Appeal Decision

Appeal Ref: 6001920

69 Chapel Lane, Heckmondwike WF16 9JR

Proposed Front Elevation (East)

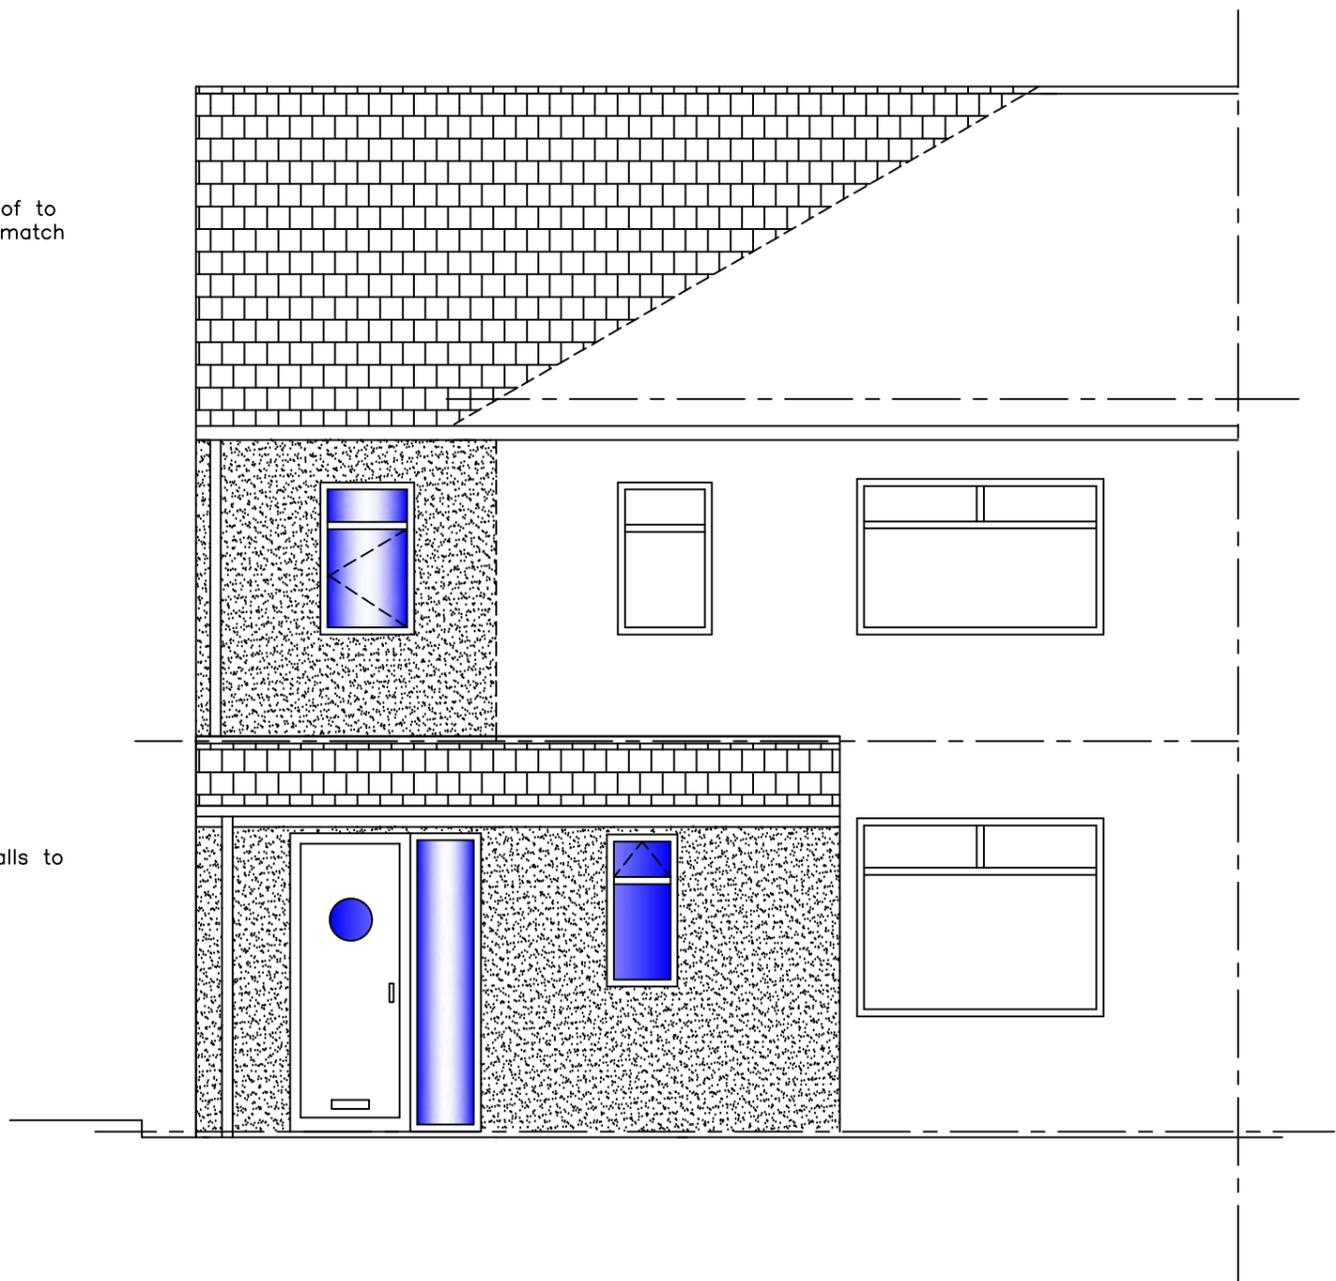
5. The proposed two storey side extension would align with the dwelling's principal elevation and span across to the boundary to abut the pavement. It would introduce a gable end, with the existing roof also altered from a hip to gable. The scale of this increase in roof volume, combined with the fundamental change to its shape, would markedly change the dwelling's existing proportions and appearance. Owing to its resulting gabled form and unduly bulky massing beside the highway, the dwelling would stand in pronounced contrast to the retained hipped roofs of neighbouring properties of the same original style, including its adjoining semi. In addition, its position would create a substantial blocking mass that would erode the current sense of openness within the streetscene.

Proposed Rear Elevation (West)

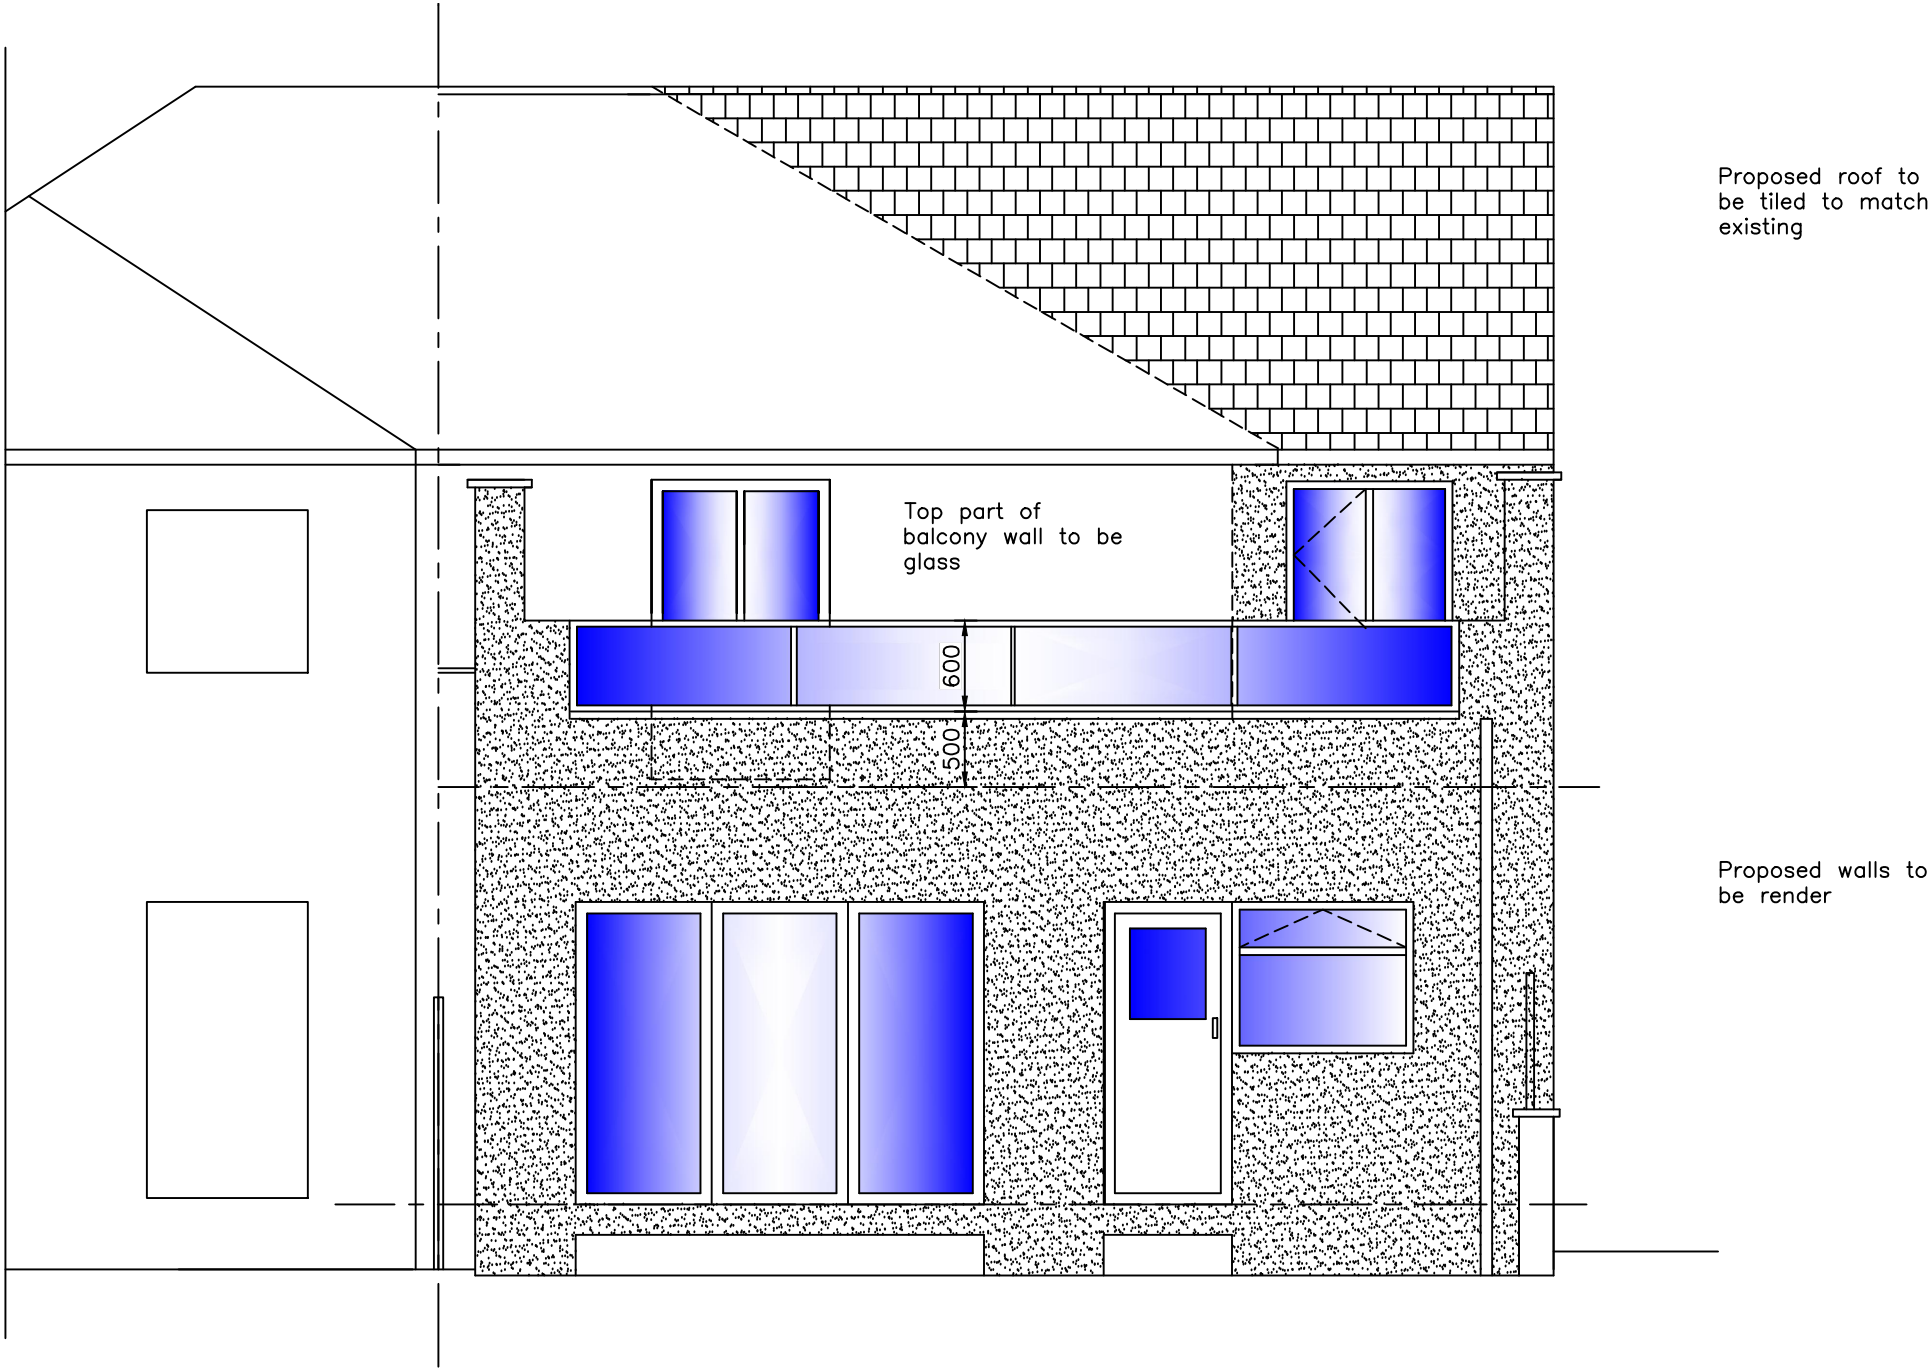
6. The proposed rear extension includes a roof-level balcony, the sides of which would be enclosed by raised wall sections extending towards the main roof's eaves and a glazed balustrade spanning most of its width. This elevated addition would be discordant to the appearance of the host dwelling and, due to its height and situation, would be seen clearly from Green Avenue as an incongruous feature within the locality.

Proposed Site Plan

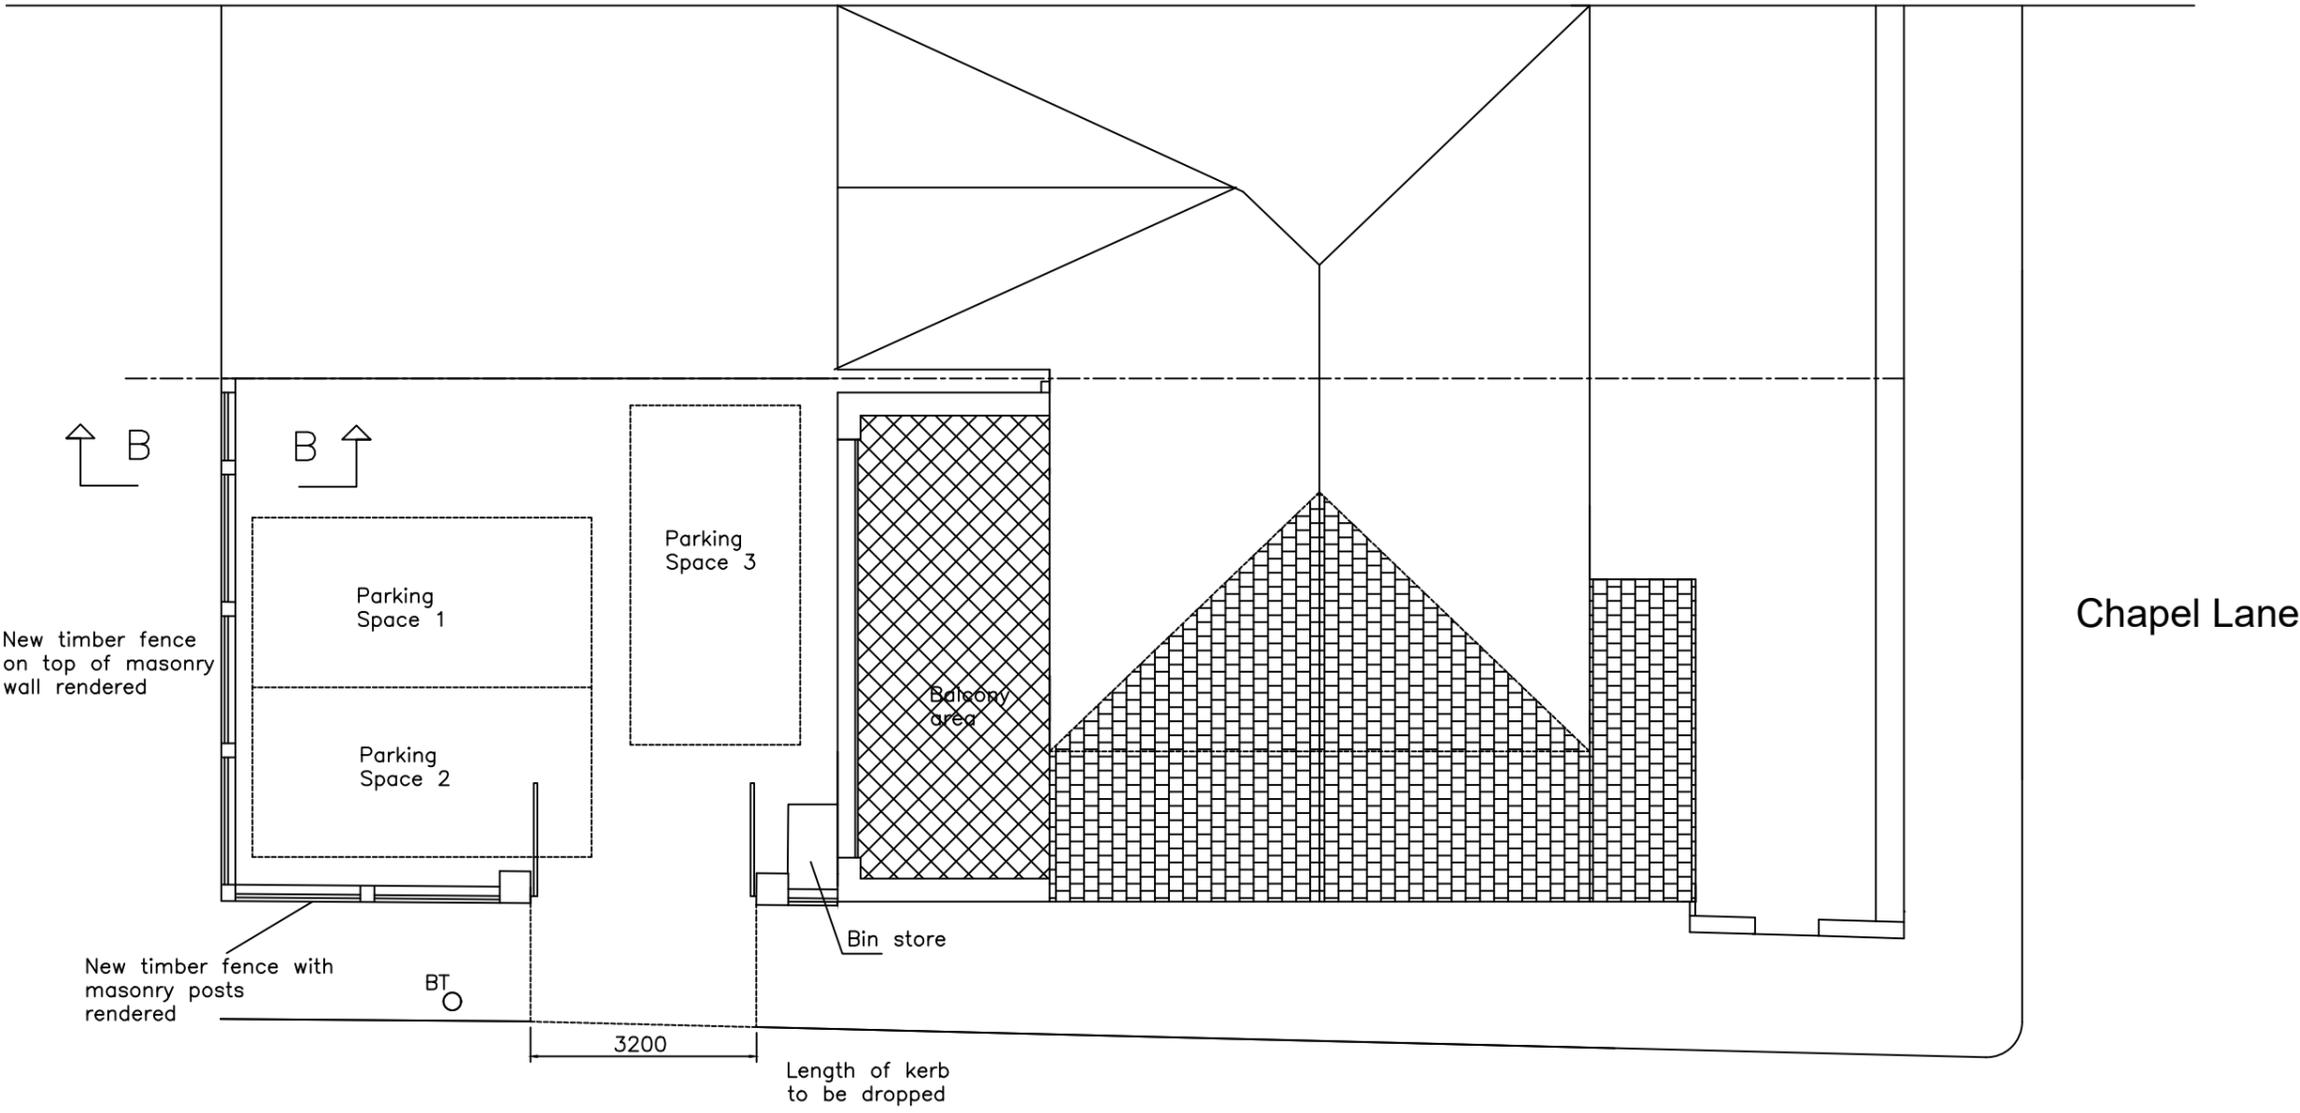
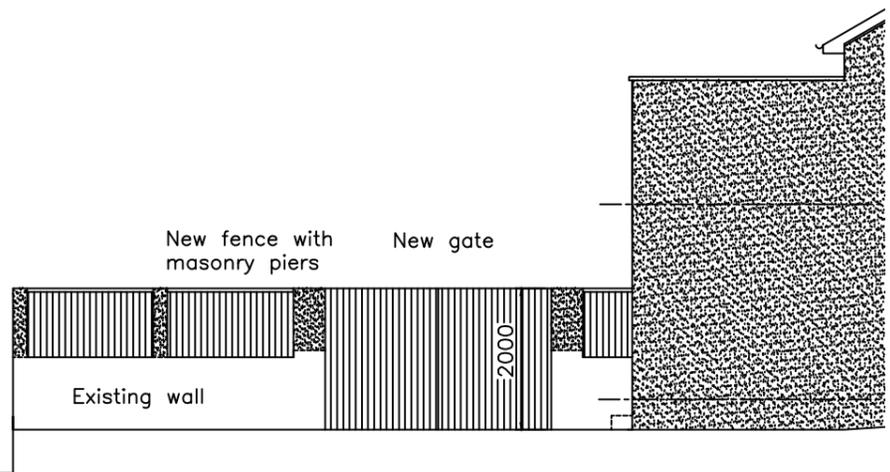
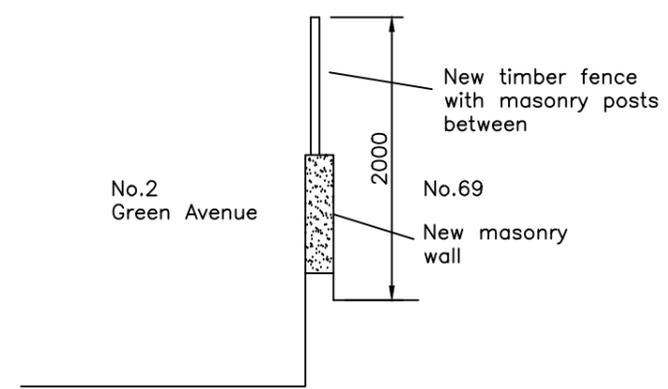
8. The appeal scheme includes fencing, piers and gates positioned on top of, and infilling a gap within, the retained section of existing side boundary wall to the rear of the proposed extension. A matching wall and fence enclosure would also be constructed along the rear boundary line. While I acknowledge that the site's rear curtilage offers little existing privacy, this openness to Green Avenue is a longstanding feature of the property. By reflecting the limited height of neighbouring boundary walls, the existing treatment contributes to the degree of spaciousness which helps define the streetscene. Consequently, the proposed much taller fencing, piers and gates beside the highway would appear at odds with the character of the area.

10. The scheme includes a dropped kerb to provide formal access to vehicle parking at the rear of the site, to be reached through the proposed gates. Although the plans do not show pedestrian visibility splays, I observed that because of their design, height and position, the gates and adjoining piers would constrain visibility for a driver emerging from the site until well onto the adjacent footway. More so if the vehicle was reversed onto the highway.
11. Given this restriction in visibility, conflict between vehicles and pedestrians passing across the dropped kerb is foreseeable, to the detriment of pedestrian safety. While

I acknowledge that Green Avenue is a no-through road serving a limited number of properties, the potential for a collision would nevertheless remain. I am therefore not satisfied that the proposal would provide safe and suitable access and consider that it would be likely to harm highway safety having particular regard to visibility. It would thus conflict with Policy LP21 of the LP, which seeks to ensure development avoids detrimental impacts on highway safety.
